Application No: FP/66/26/PL
Site Address: Rabbit Island Rear of 84 Brooks Lane Bognor Regis PO22 8DN
Description of works: Retention of an existing agricultural barn previously approved under FP/106/23/AG with a total roof height of 4.2m (compared to 2.9m as permitted). This application is in CIL Zone 5 (Zero Rated) as other development.

OWPC84651

Felpham Parish Council OBJECT to this application on the following grounds:

Drawing: Elevations and floor plan

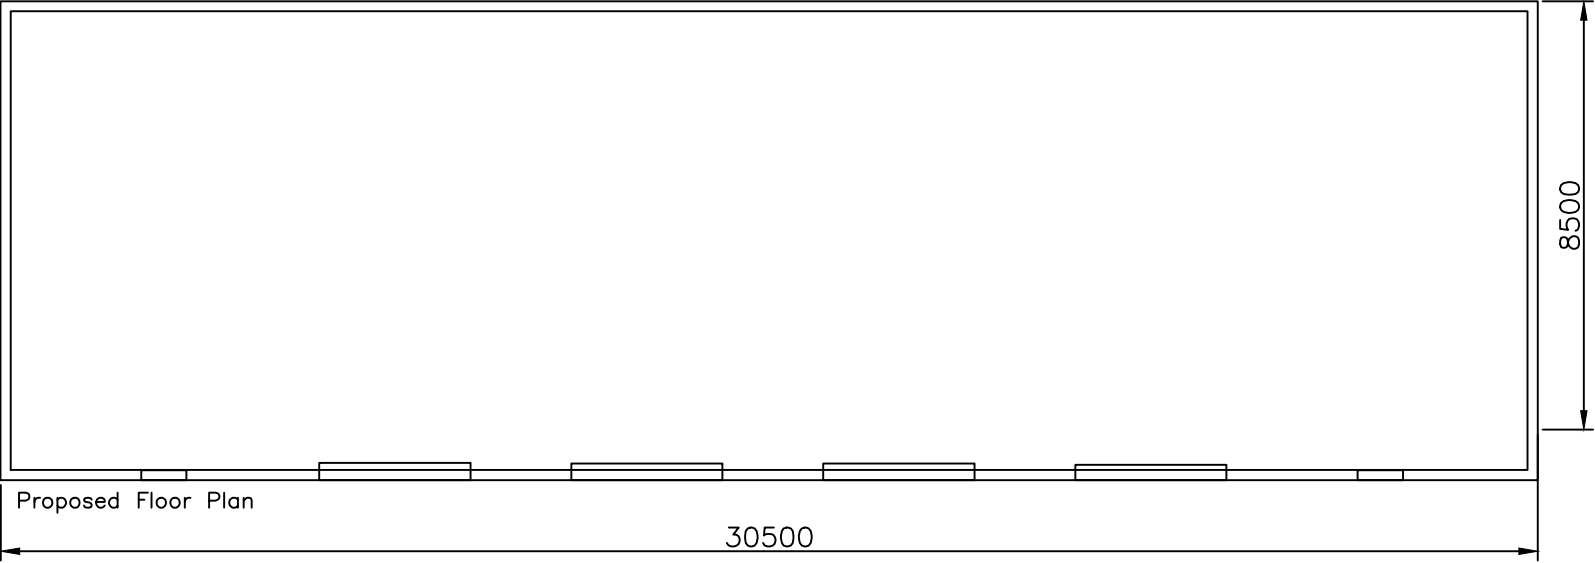
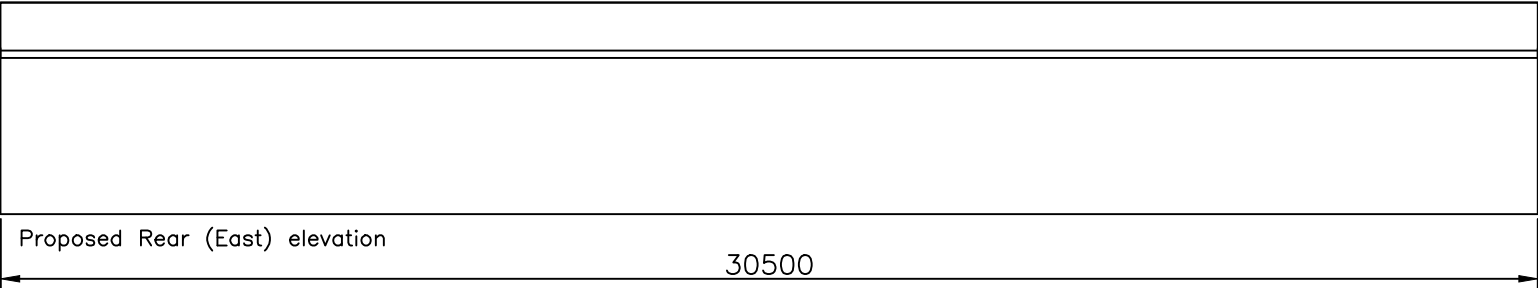
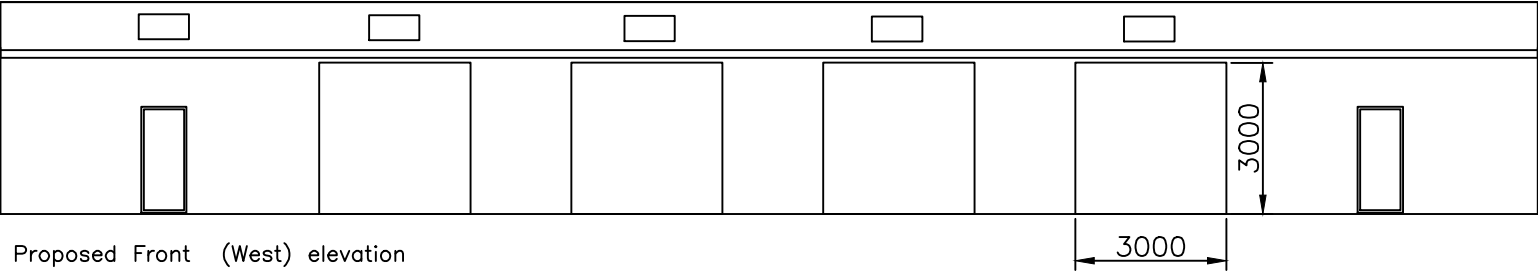
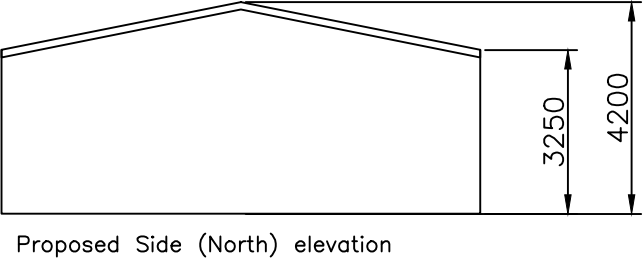
The barn has instead been constructed to an overall height of approximately 4.2 metres, representing an increase of around 45% over the approved height. This is not a minor variation but a material change to the scale, bulk and visual impact of the building.

The additional height makes the building substantially more prominent within the rural landscape and results in a structure that is materially different from that which the Council previously considered acceptable. No compelling planning justification has been provided to demonstrate why the approved design could not have been constructed or why the additional height is necessary for agricultural purposes.

As per refusal FP/91/23/AG: Part 6, Class A, A.1 of the Town and Country Planning Act (General Permitted Development) Order 2015 (as amended) states that development is not permitted where (f) the height of any part of any building, structure or works within 3 kilometres of the perimeter of an aerodrome would exceed 3 metres. The site is within 105m of the LEC Airfield which meets the definition of an aerodrome. As such, the
